APPENDIX C**El Paso County Land Development Code, Appendix B:
GUIDELINES AND REGULATIONS FOR AREAS AND ACTIVITIES
OF STATE INTEREST****Chapter 7 - SITE SELECTION AND EXPANSION OF AIRPORTS****Article 2 Permit Application and Procedures****Table of Contents****Section 7.201. Application Submission Requirements**

The FAA approved Airport Layout Plan (ALP) is contained as Chapter 7 of the Meadow Lake Airport Master Plan Update [Reference (b)] and attached separately as Reference (c):

| JVIATION® | | MEADOW LAKE AIRPORT | | ISSUE RECORD | | AIRPORT LAYOUT PLAN | | LAND USE DRAWING | | SHEET 19 OF 19 | |

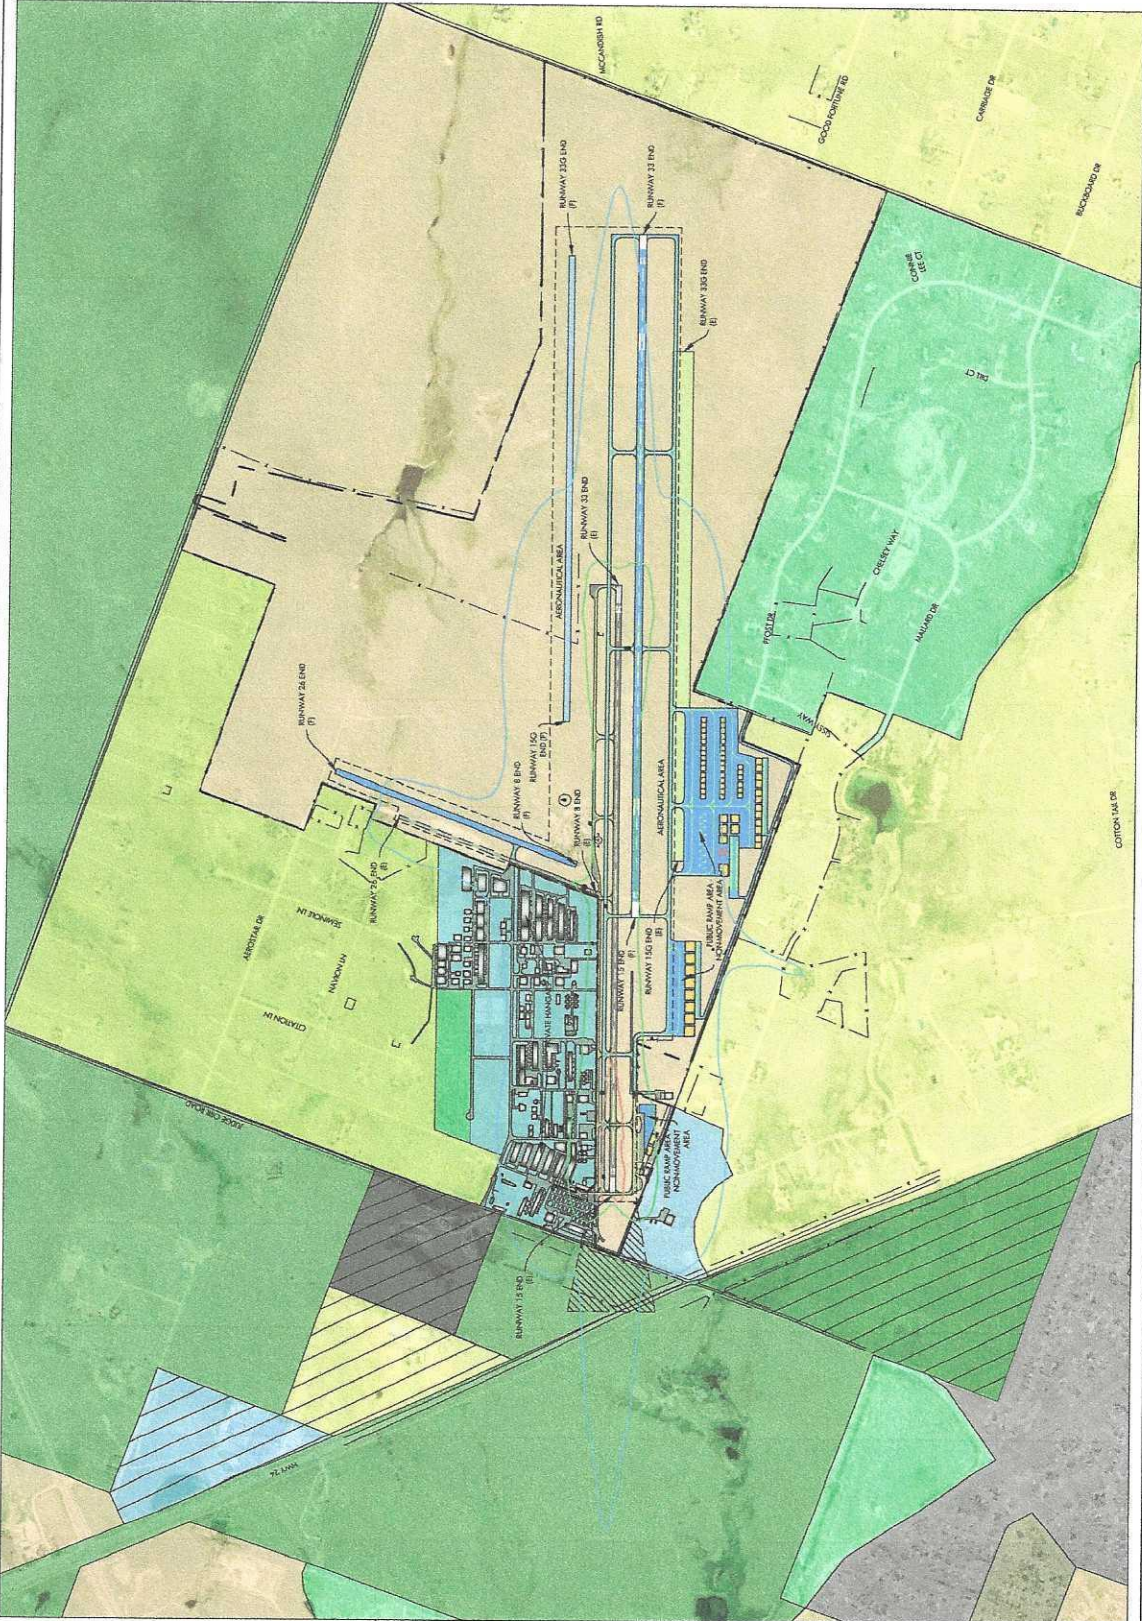
update to today's - 6 year old info not acceptable; much has changed in the last 6 years

no reference h submitted; what does this sentence mean? Are you asking the County to limit uses?

airport master plan? This is a year 2022 1041 submittal not a master plan

provide a new sheet as new exhibit -

where would be aviation school be? is it on the ALP? Is there any club-restaurant possible? that needs to be added to the exhibit?
